Current Zoning: R-17MF(CD) (multi-family residential, conditional)
Proposed Zoning: R-22MF(CD) (multi-family residential, conditional)

Approximately 4.2 acres located on the east side of West W.T. Harris Boulevard, north of Interstate 485, and south of Mt. Holly-Huntersville Road.

The petition proposes to allow up to 92 multi-family residential units on a vacant parcel previously rezoned via petition 2019-184 to permit up to 71 age restricted multi-family units in a single building.

Staff recommends approval of the petition upon resolution of the outstanding issue related to site and building design.

RZ1.00

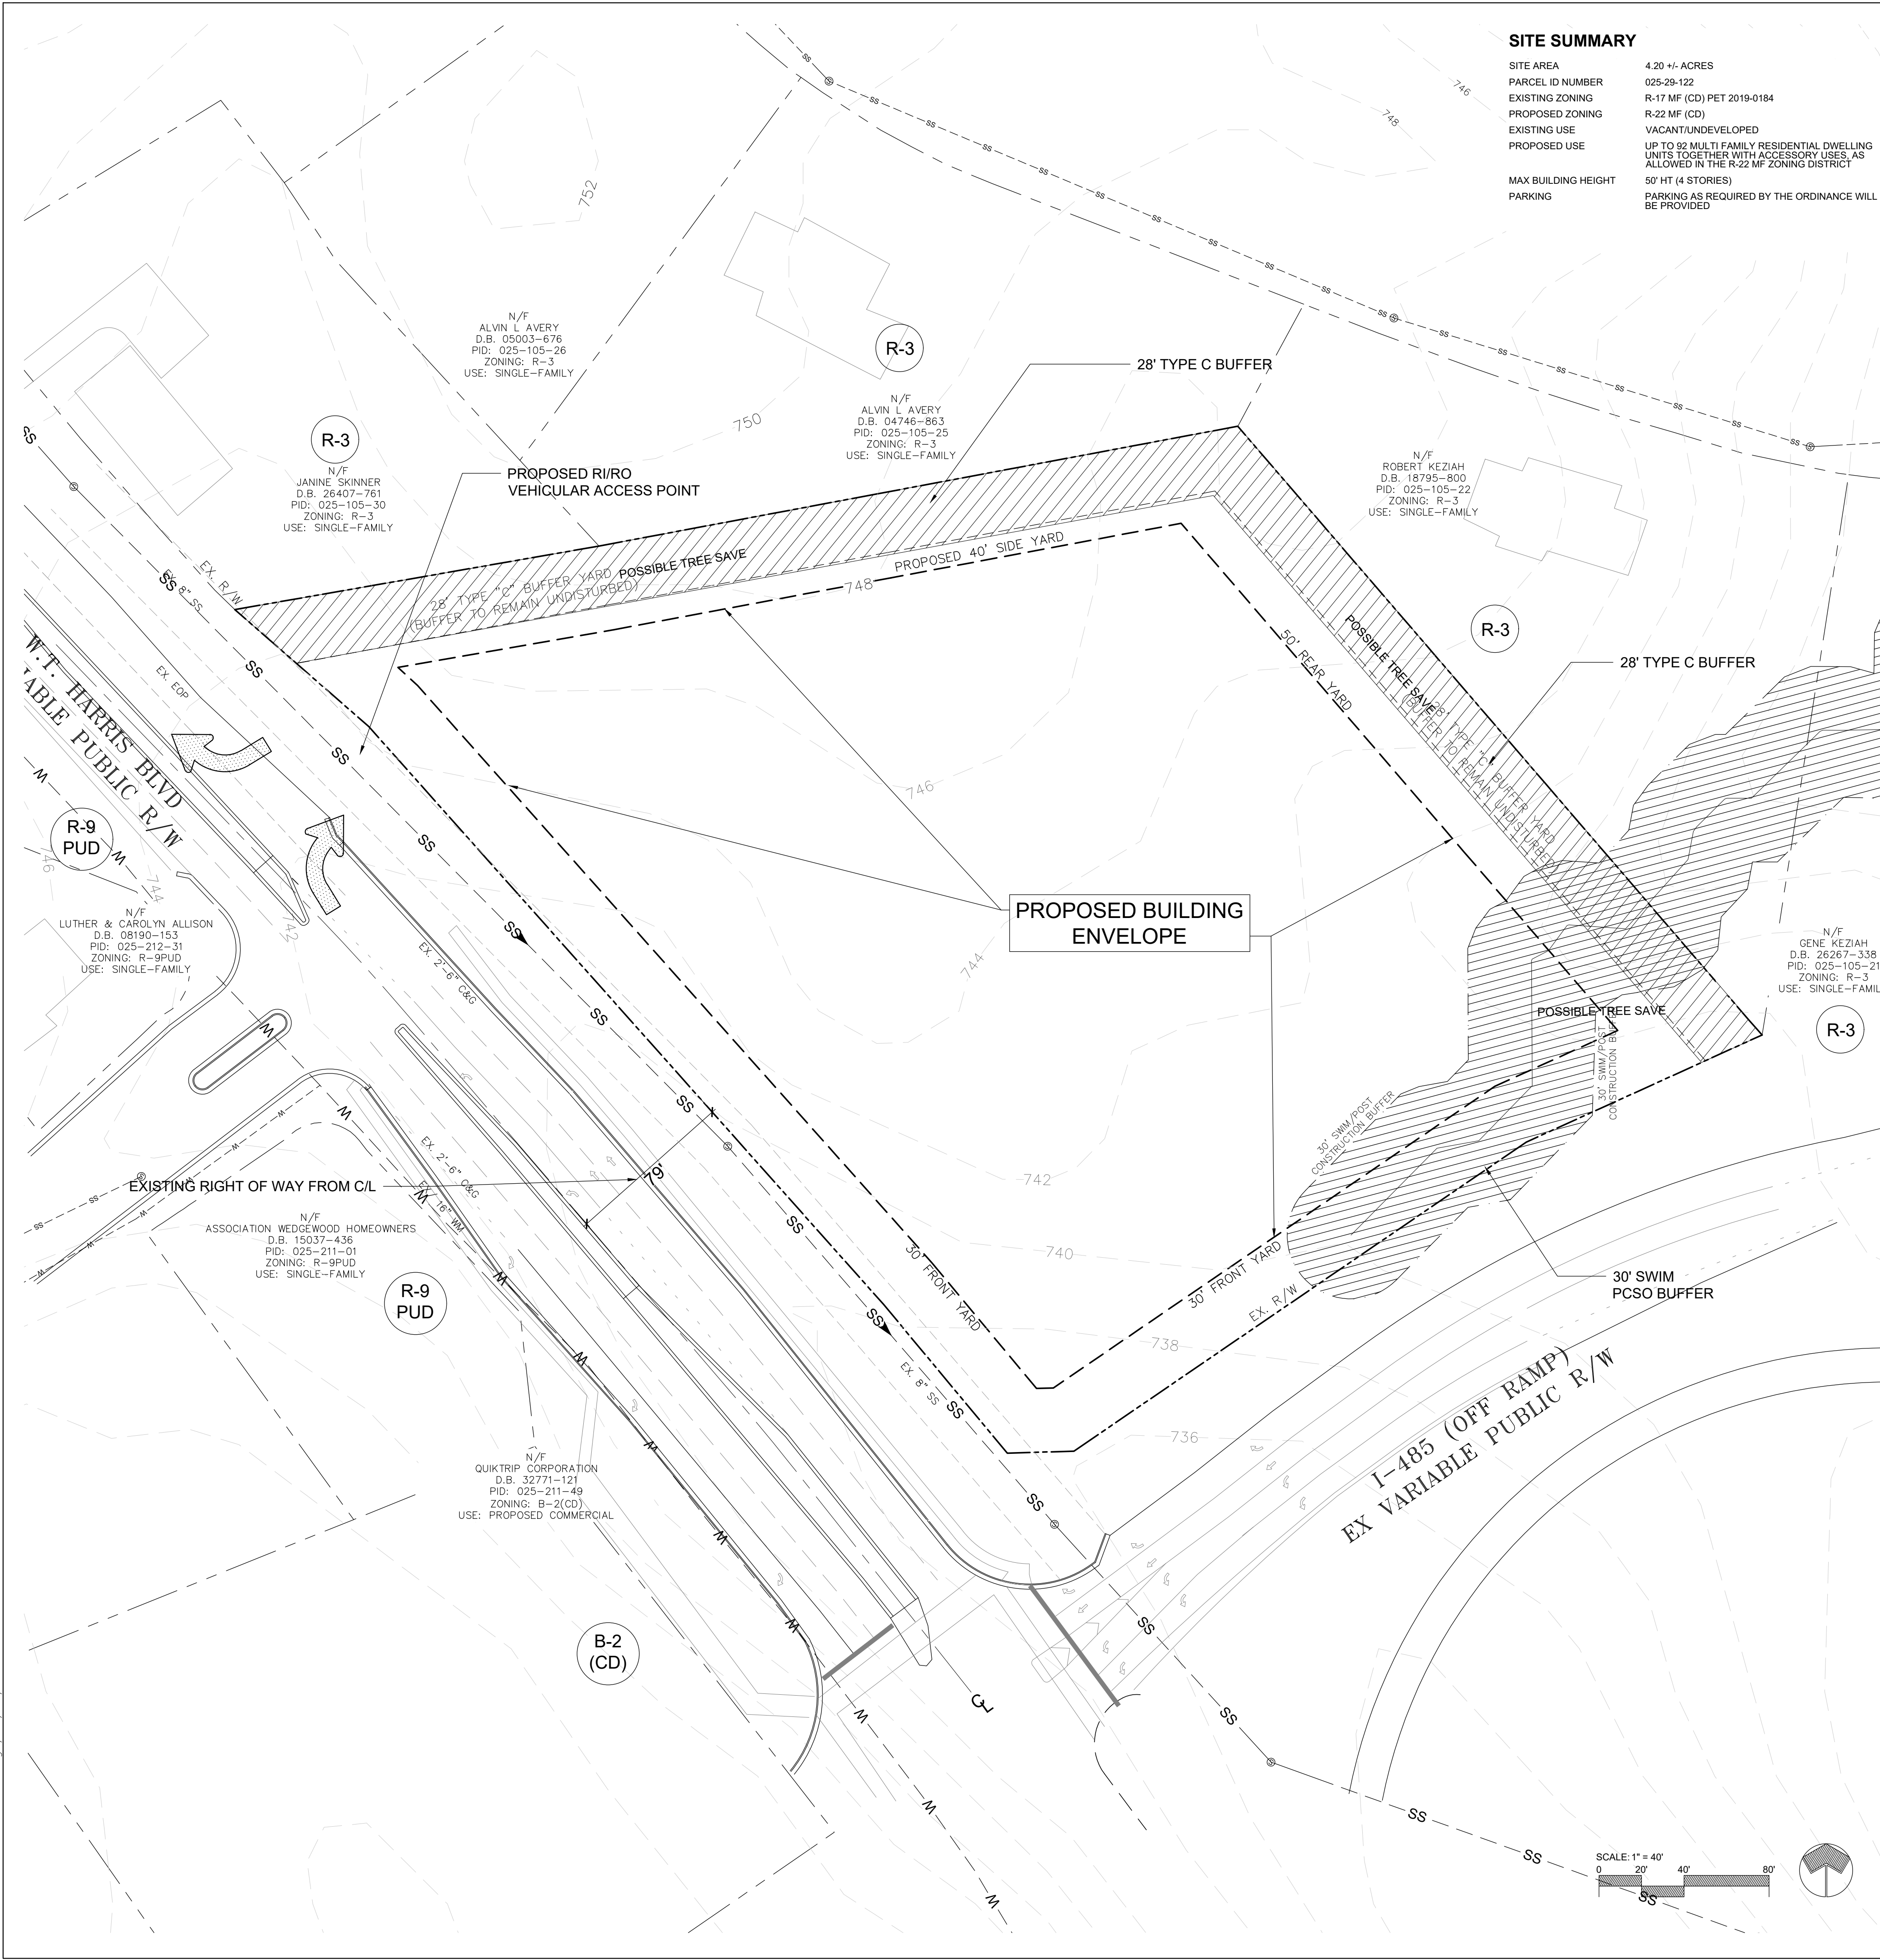
- Increased yards will need to be provided per the ordinance for the increased height abutting single family residential zoning. **Petitioner has added a note stating side and rear yards will be provided by the ordinance and as generally depicted on the rezoning plan. Along the northern property line a 40-foot side yard will be provided as indicated on the proposed site plan. Building height, not to exceed 50 feet, will be provided per the ordinance requirements.**
- ~~3. Development Note D-1. proposes two principal buildings, but one building is illustrated on the site plan. Please ensure information is consistent.~~ **Addressed**

- ~~1. Label and dimension curb and gutter on the site plan.~~ **Addressed**
- ~~2. A site plan note specifying that all transportation improvements will be approved and constructed before the site's first building certificate of occupancy is issued as needed. The petitioner may phase transportation improvements if said improvements and phasing are explicitly described in site plan notes. Remove existing conditional note 3D.~~ **Addressed**

D. ALL REQUIRED ROADWAY IMPROVEMENT WILL BE APPROVED AND CONSTRUCTED PRIOR TO THE ISSUANCE OF THE CERTIFICATE OF OCCUPANCY FOR THE FIRST BUILDING ON THE SITE SUBJECT TO THE PETITIONER ABILITY TO WORK WITH CDOT TO ALLOW A BOND TO BE POST FOR ANY IMPROVEMENTS NOT IN PLACE AT THE TIME OF THE ISSUANCE OF THE FIRST CERTIFICATE OF OCCUPANCY.
